Ref: D2016/31068

**Woodlawn Bioreactor Expansion Project (Major Project 10\_112) – Modification Application**

I refer to the exhibition of documents relating to the above modification application. Water NSW has reviewed the documents available on the Department's website and offers the following comments for consideration.

**Figure 1.2** Modification area site plan

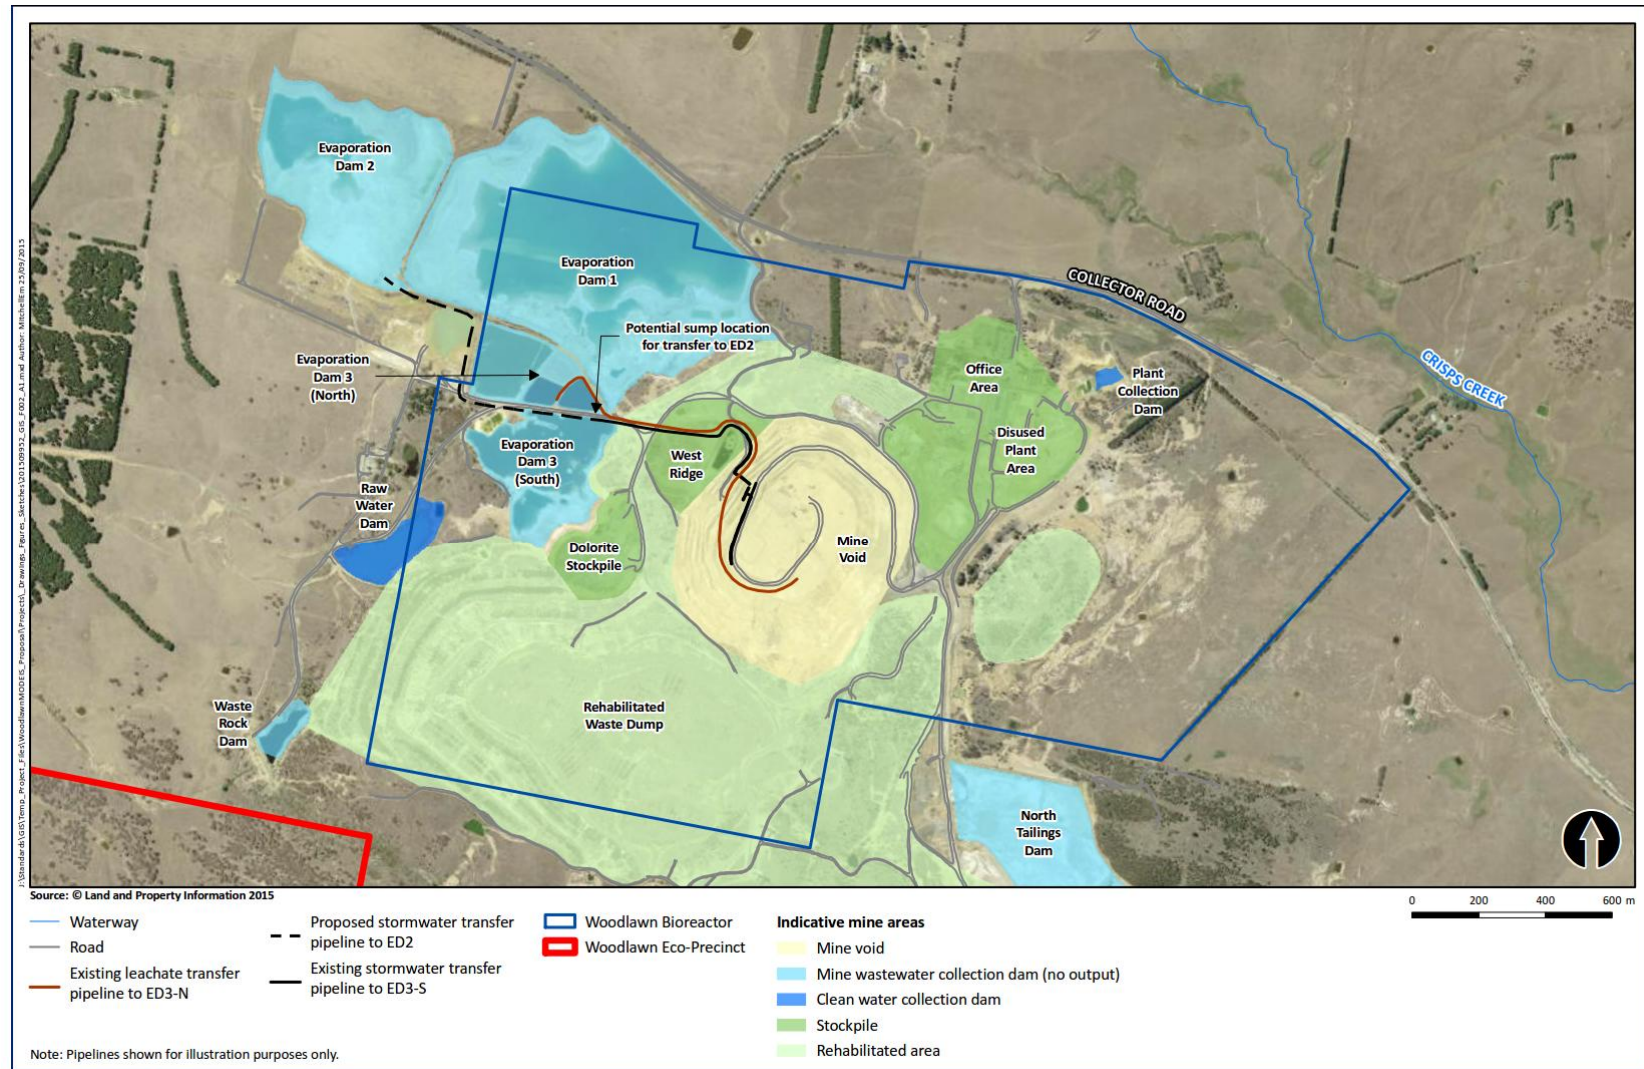
The area labelled Evaporation Dam 3 (North) in Figure 1.2 of the application document is totally within the Sydney Drinking Water Catchment. The areas labelled Evaporation Dam 3 (South) and Evaporation Dam 2 are partly within the Sydney Drinking Water Catchment.
